SOUTH ACADEMY BUSINESS CENTER

Upon inspection, the physical site did not match what is proposed on the site development plan. Update site development plan to show what is being proposed on site. There were several extra containers on site.

SHEET
 1 of 5

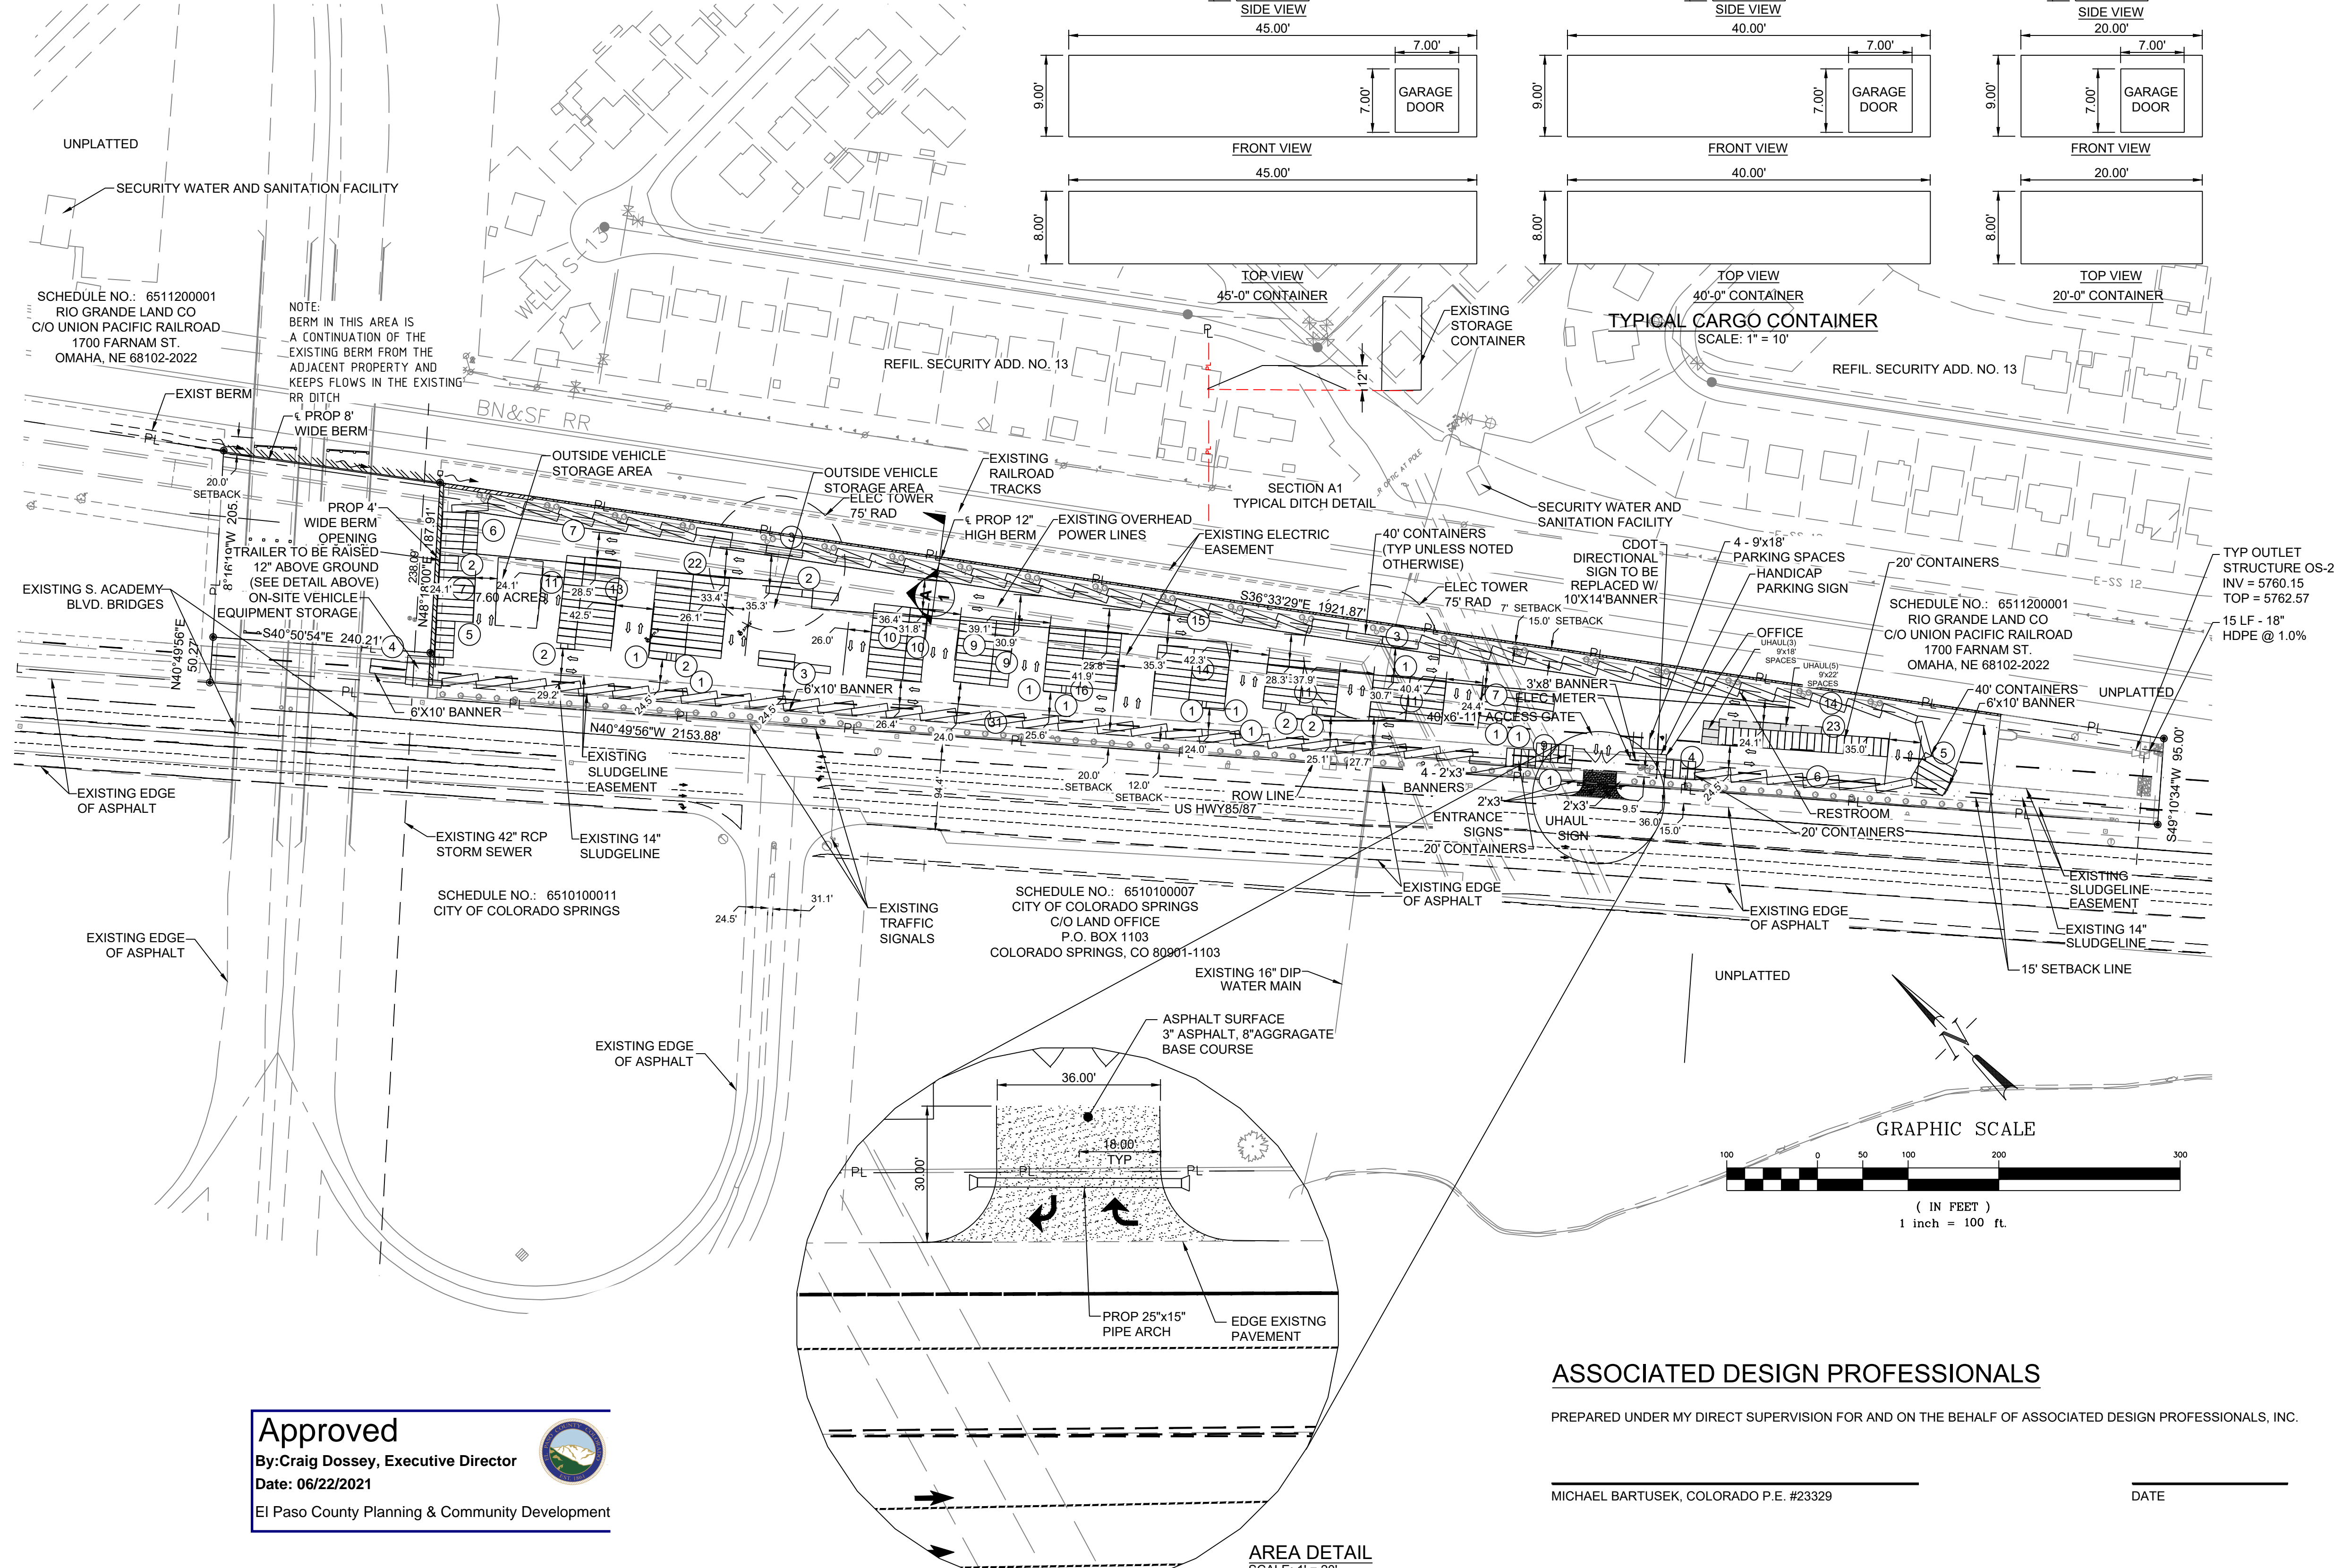
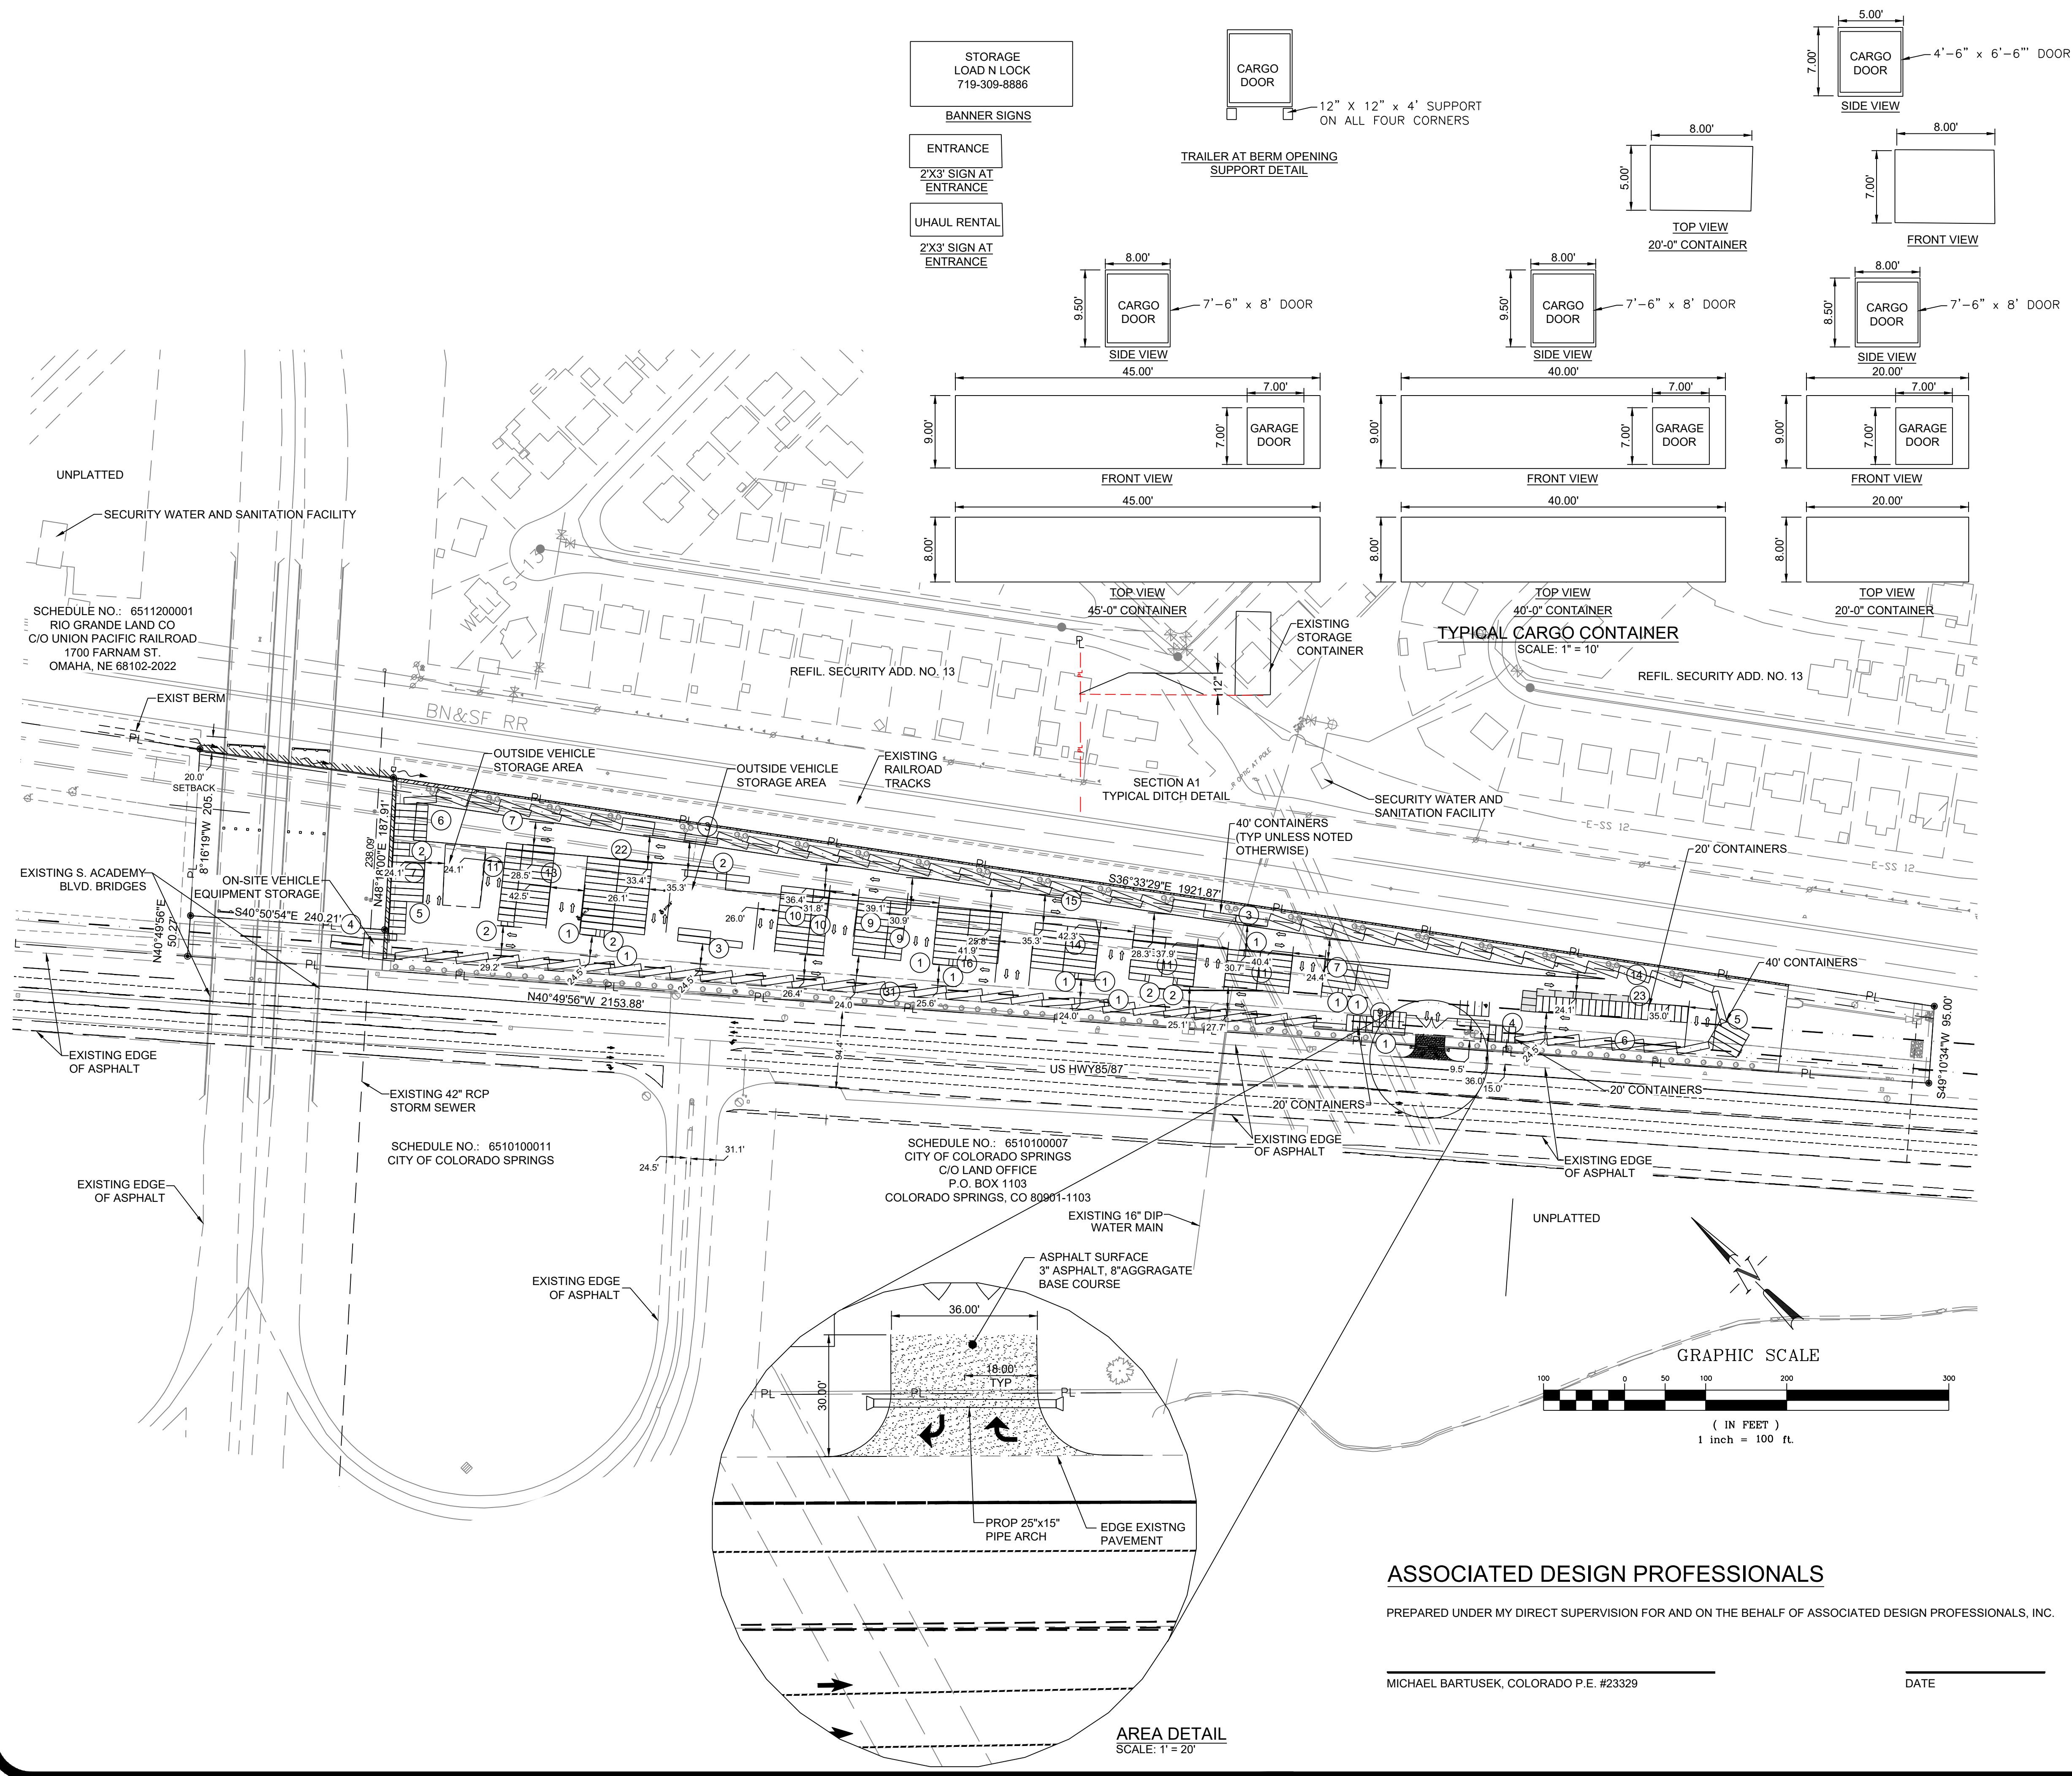
Upon inspection, outside vehicle storage will not allow access to containers. This will not be an allowed use due to the lack of space.

The site development plan will need to meet requirements from chapter 6 of the LDC in regards to drive aisles and outside vehicle storage. Doors to the storage containers must be able to be opened. 2-way drive aisle width must be 24'.
